4 November 2019

SSD 9601 Horsley Park Brickworks Plant 2 Upgrade

WaterNSW has reviewed the Environmental Impact Statement (EIS) and associated documents submitted by WillowTree Planning on behalf of The Austral Brick Co Pty Ltd (the Applicant) and finds the EIS documentation does not adequately address the following:

STORMWATER CATCHMENT LEGEND

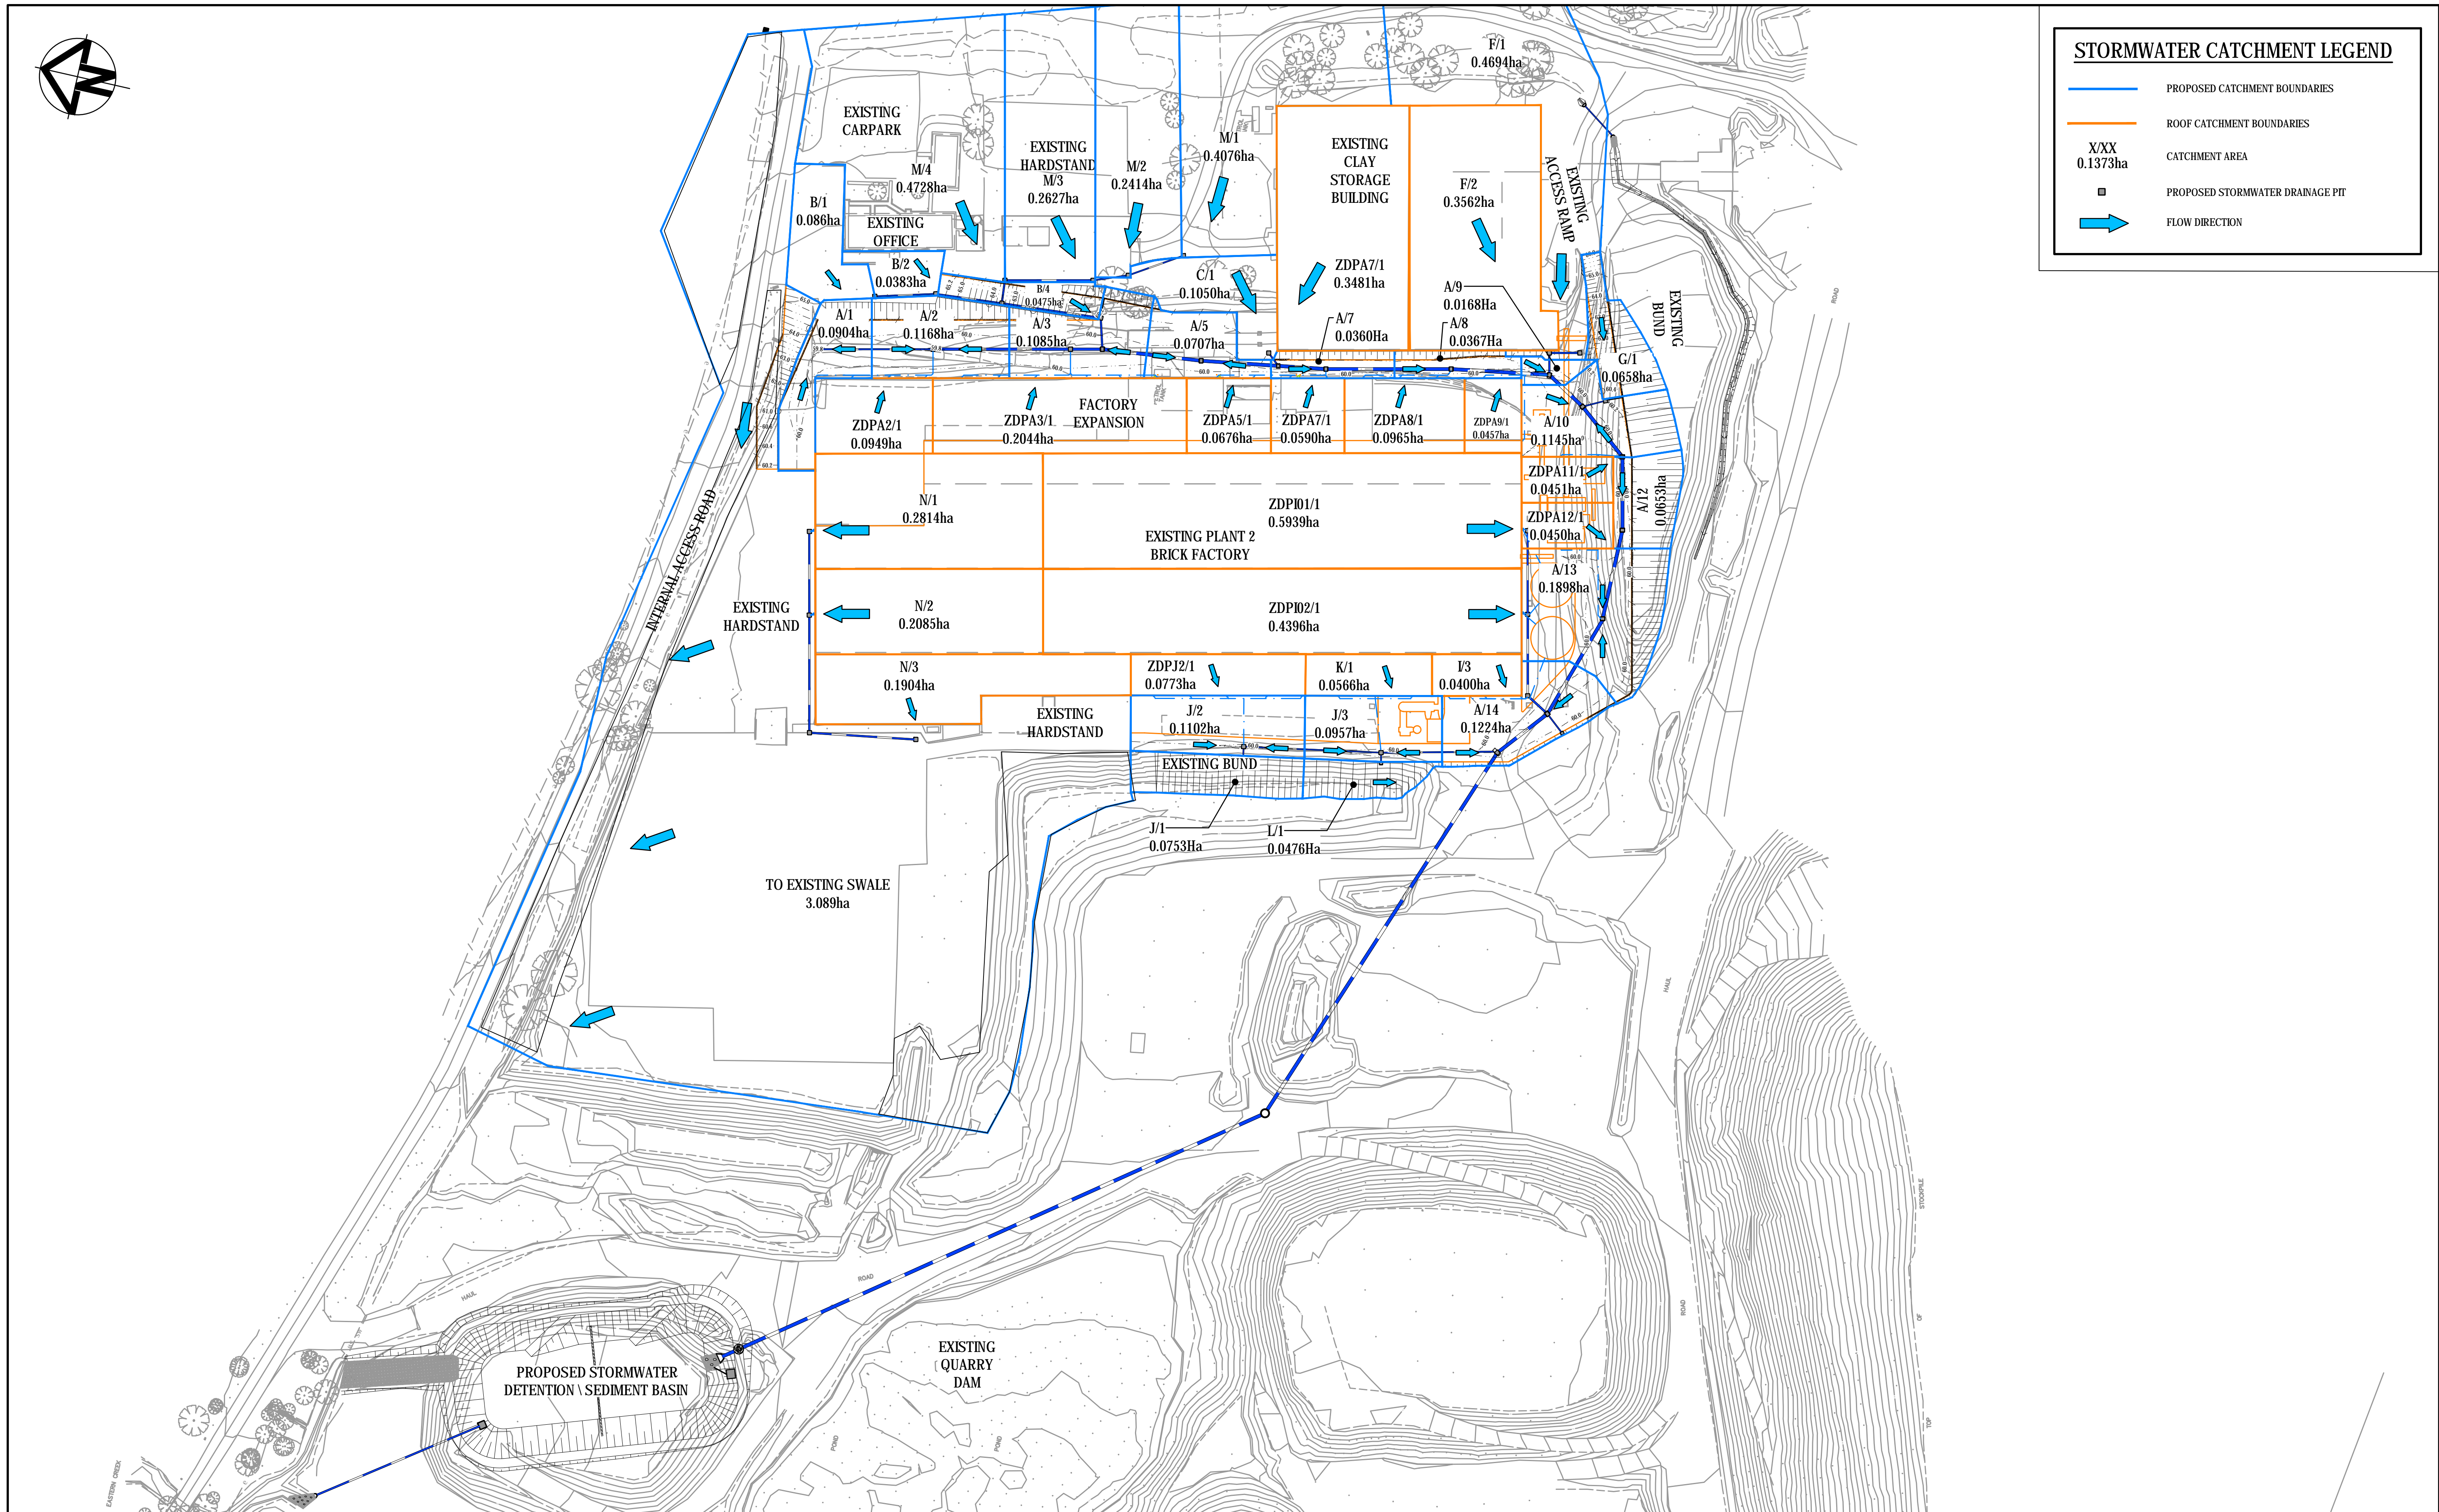
Stormwater discharge quantities into Eastern Creek pre- and post-development are not identified in the Civil Design Report (at&I, May 2019). It is understood that a new on-site detention basin will be constructed to the northwest of the site as part of this proposal, with flows conveyed from the development site across WaterNSW lands along Eastern Creek. At this location, WaterNSW lands

The proposed detention basin is expected to reduce the peak rate of stormwater flows into Eastern Creek by temporarily storing water and releasing it at a controlled rate over a longer period of time. Given the Pipeline access constraints and risk to infrastructure, WaterNSW is concerned that the detention basin may still release water long after the storm event is over.

As per WaterNSW's Guidelines for development adjacent to the Warragamba Pipelines Corridor, WaterNSW requires that post-development flows that enter or are conveyed across the Pipelines corridor must be equal to or less than the pre-development flows for each storm event up to and including 1% AEP event.

- additional modelling be provided to show the stormwater flow properties (both velocity and water level) for the predeveloped and post developed scenarios. At a minimum, this must be completed at the location of the intersection of the Pipelines corridor and Eastern Creek
- during detailed design stage, measures must be developed ensure flooding and associated water quality and quantity risks within the Pipelines corridor are mitigated
- additional information is provided regarding the pipes associated with the detention basin to demonstrate mitigation measures proposed if the pipes are blocked and the blockage factor
- the development will have a neutral or beneficial effect (NorBE) on water quality.

- *The proposal must not result in an increase in overland flow water into the Pipelines corridor of either quantity, quality or velocity. The development must be designed, operated and maintained to ensure post-development flows do not exceed pre-development flows into and through the Pipelines corridor.*
- *Stormwater directed to or across the Pipelines corridor is not acceptable, except at approved point of discharge for the development.*
- *The proposal must have a neutral or beneficial effect on water quality.*

Status	FOR REVIEW NOT TO BE USED FOR CONSTRUCTION	A1
Drawing No.	DAC060	Issue
Project No.	18-577	C

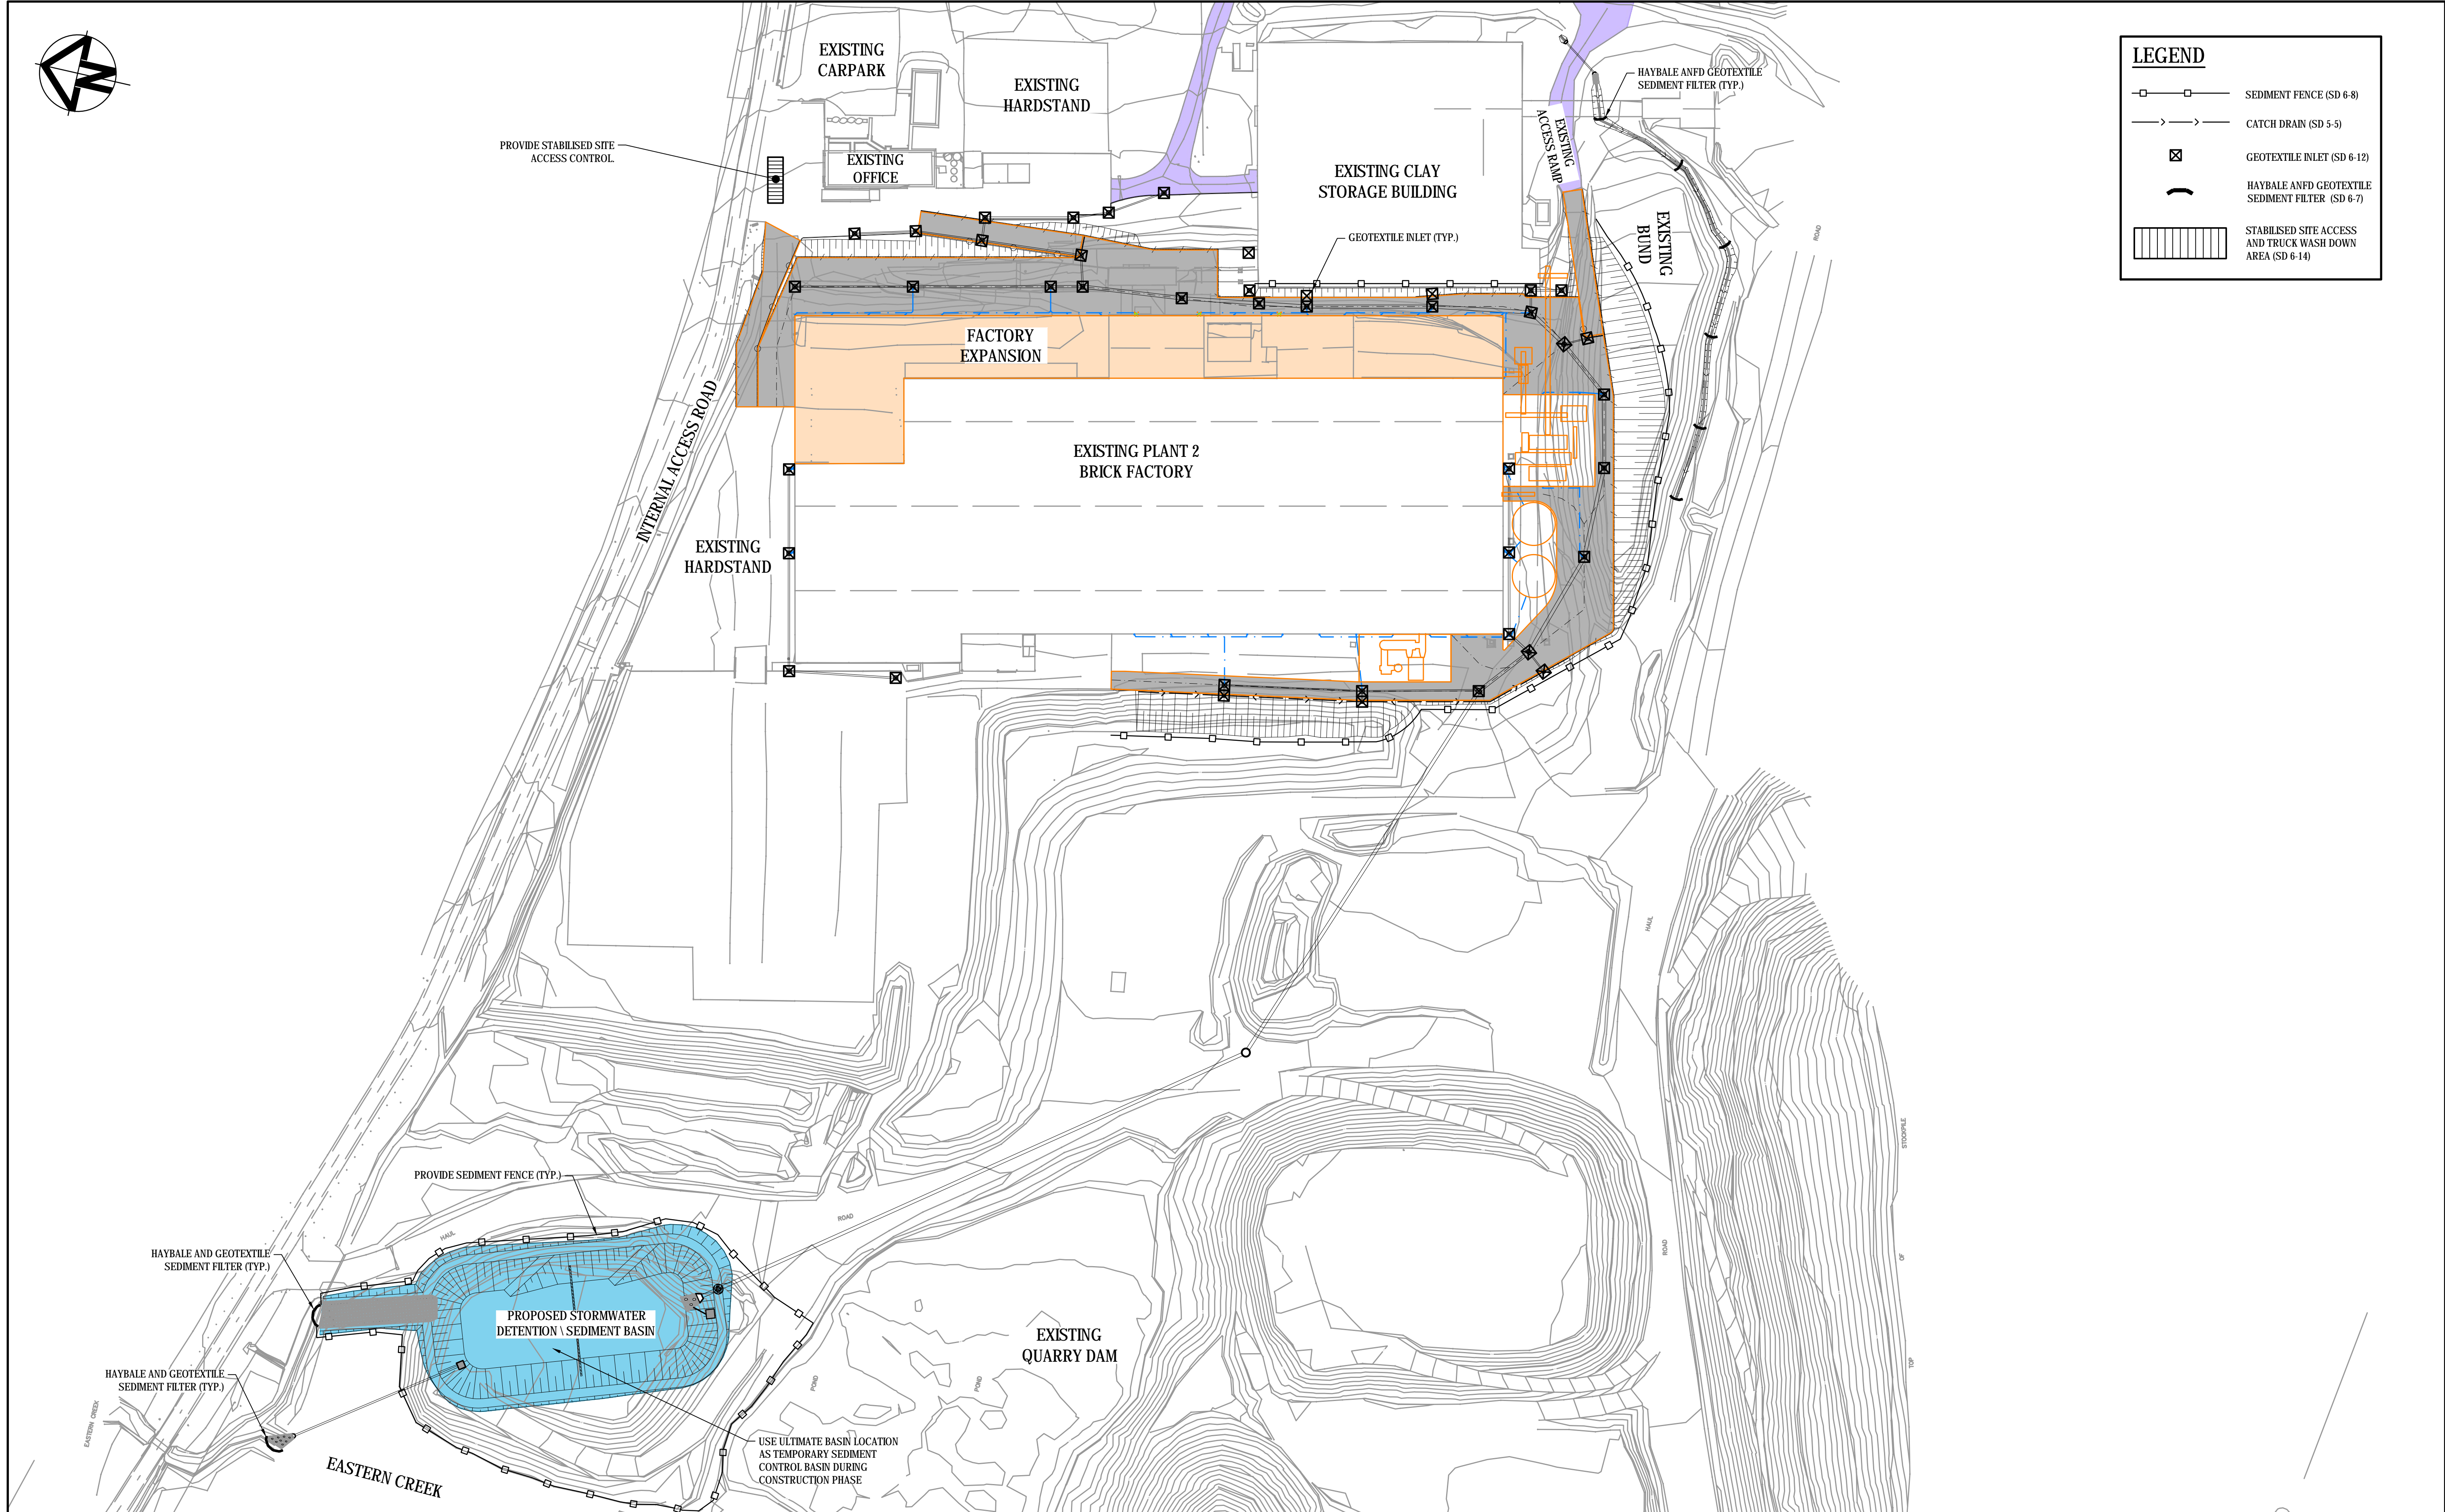
It is critically important that the bulk earthworks are designed and undertaken in a manner that does not impact on the Pipelines corridor. Effective erosion and sediment control must be installed prior to any earthworks. The controls should be regularly maintained and retained until works have been completed and the ground surface stabilised or ground cover re-established.

- *Erosion and sediment controls are to be designed, installed and maintained in accordance with the Blue Book, Landcom (2004) Managing Urban Stormwater: Soils and Construction.*
